Response to: "Western Façade should have additional external sun shading"

Sydney December 17, 2021

New Liverpool Public School

1 Block Y Elevation - West
1 : 100

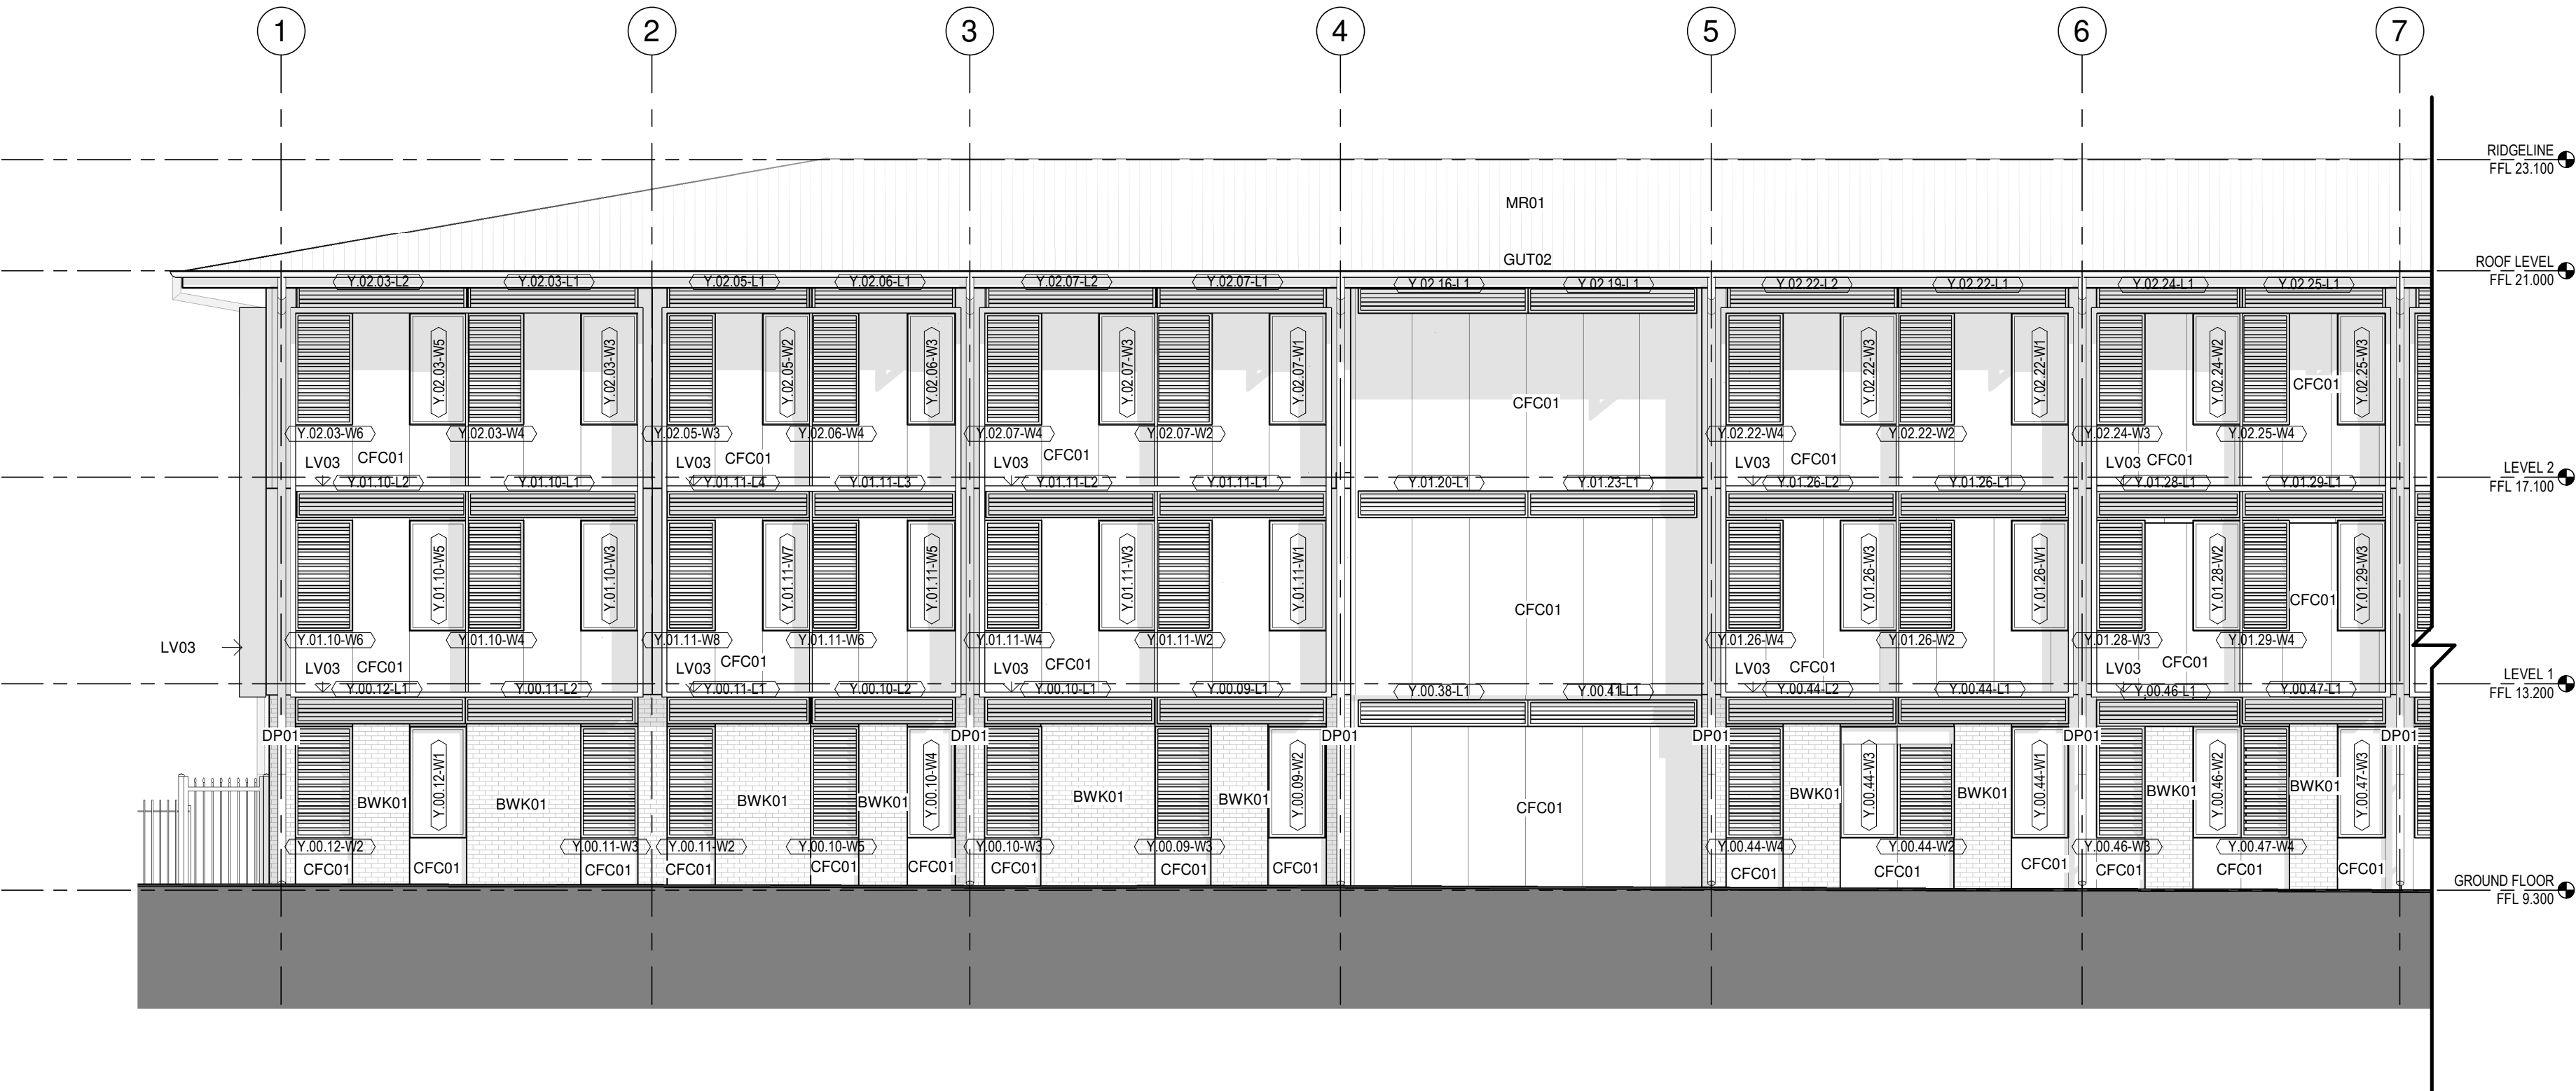
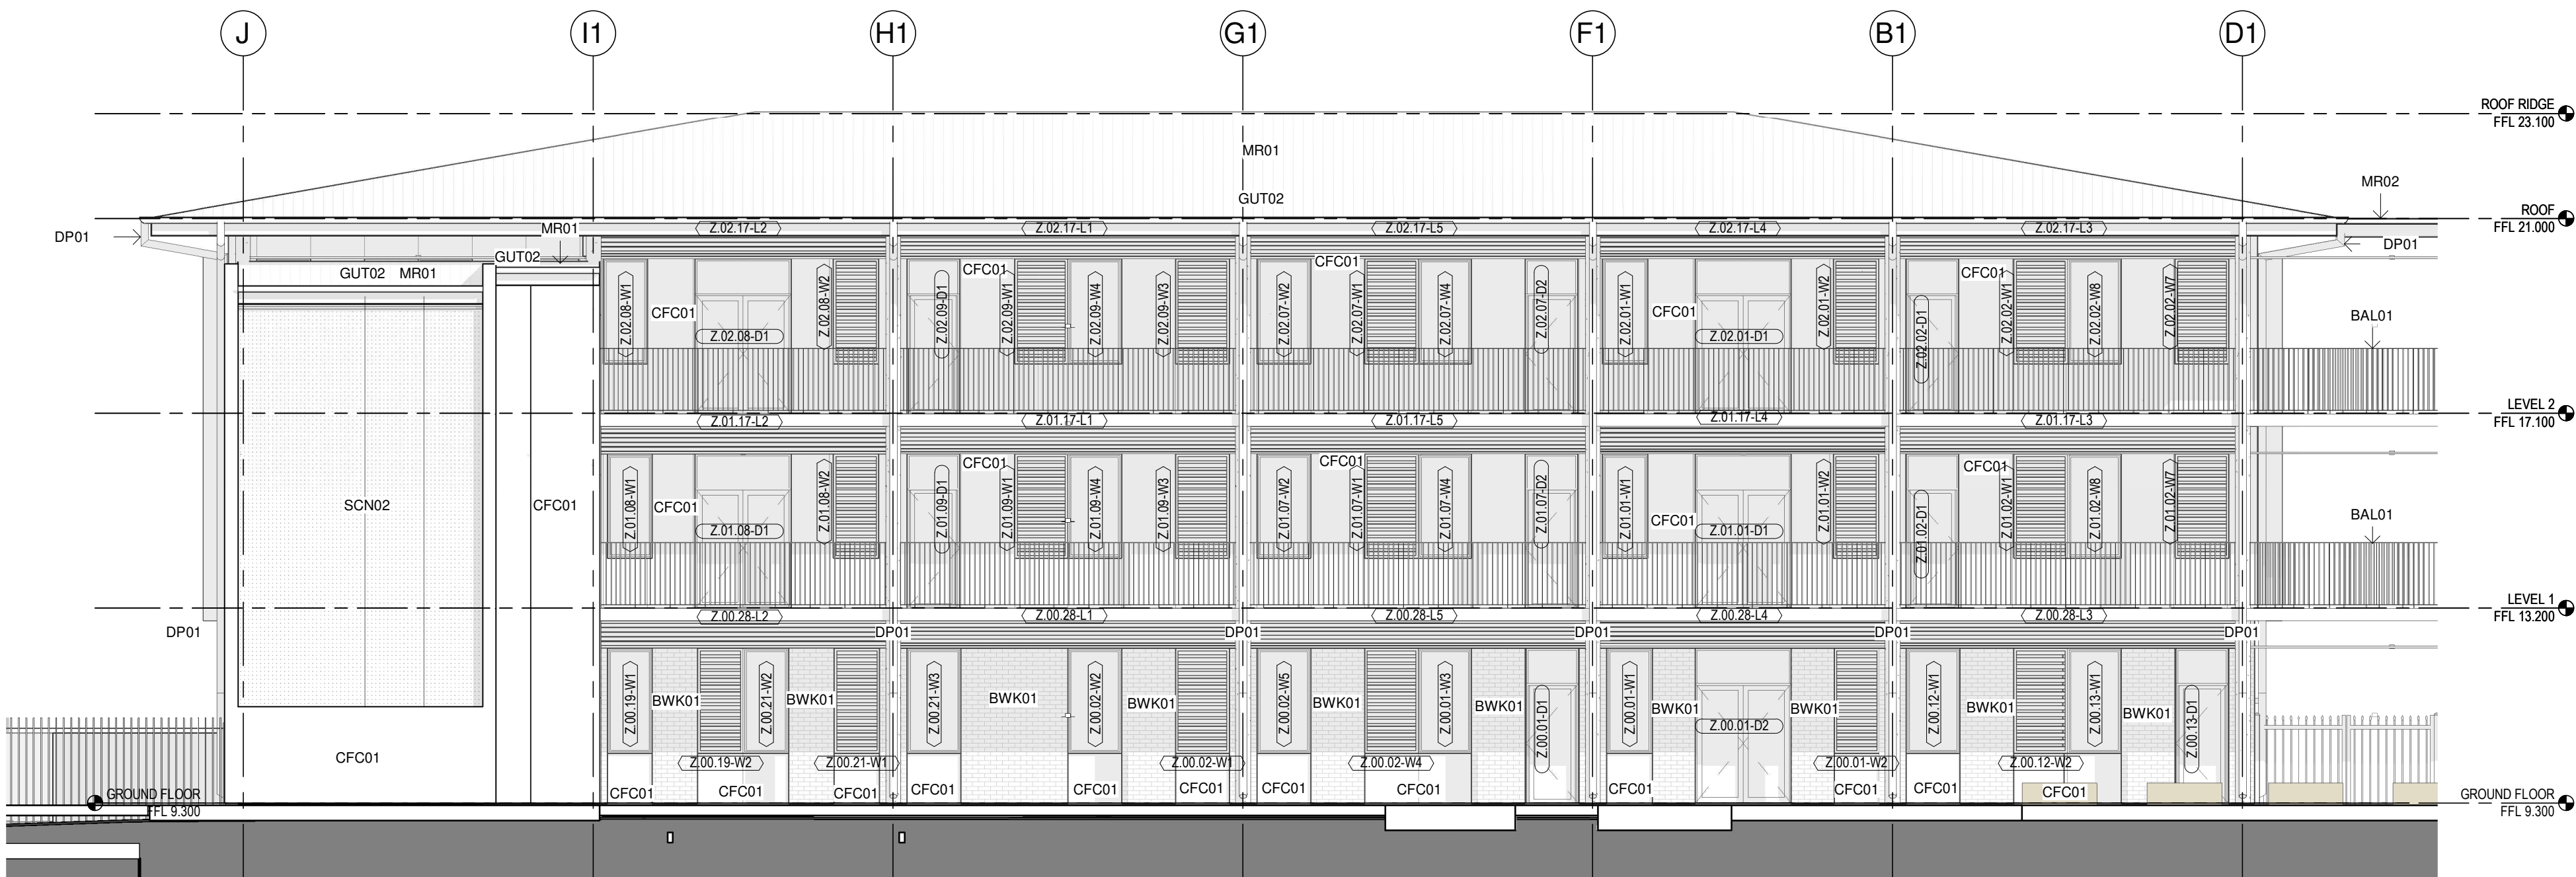
It is acknowledged that the proposed shading on the Western façade could be more effective, however, vertical shading (unless angled and of a reasonable size) will be of limited performance, due to the high extent of changes in the altitude and azimuth of the sun's position.

Large shading devices which would effectively shade the Western façade are likely to compromise good levels of daylight, views, and ventilation. As such, the proposed solution was to:

- 1) Increase the glazing performance on the West from a purely compliant (NCC 2019) SHGC of greater than 0.6, to an SHGC of approx 0.5 (final values to be confirmed)
- 2) To avoid unwanted thermal loads (conduction and solar) and glare concerns, the recommendation for the glazing percentage (window to wall ratio) on the East and West façades, was to be in the order of 25-35%. The initial concept proposed 45%, this has subsequently been reduced to 23%.

Daylight studies have confirmed that with the proposed glazing ratio on the West (23%), the classrooms achieve good levels of daylight (160 lux over 80% of the time in 40% of the nominated areas), as per the EFSG requirements. Sun studies have been undertaken to assess the impact of the sun on the Western façade. When the shading is not effective, blinds will assist for the remaining hours of the school day (up to 15:30).
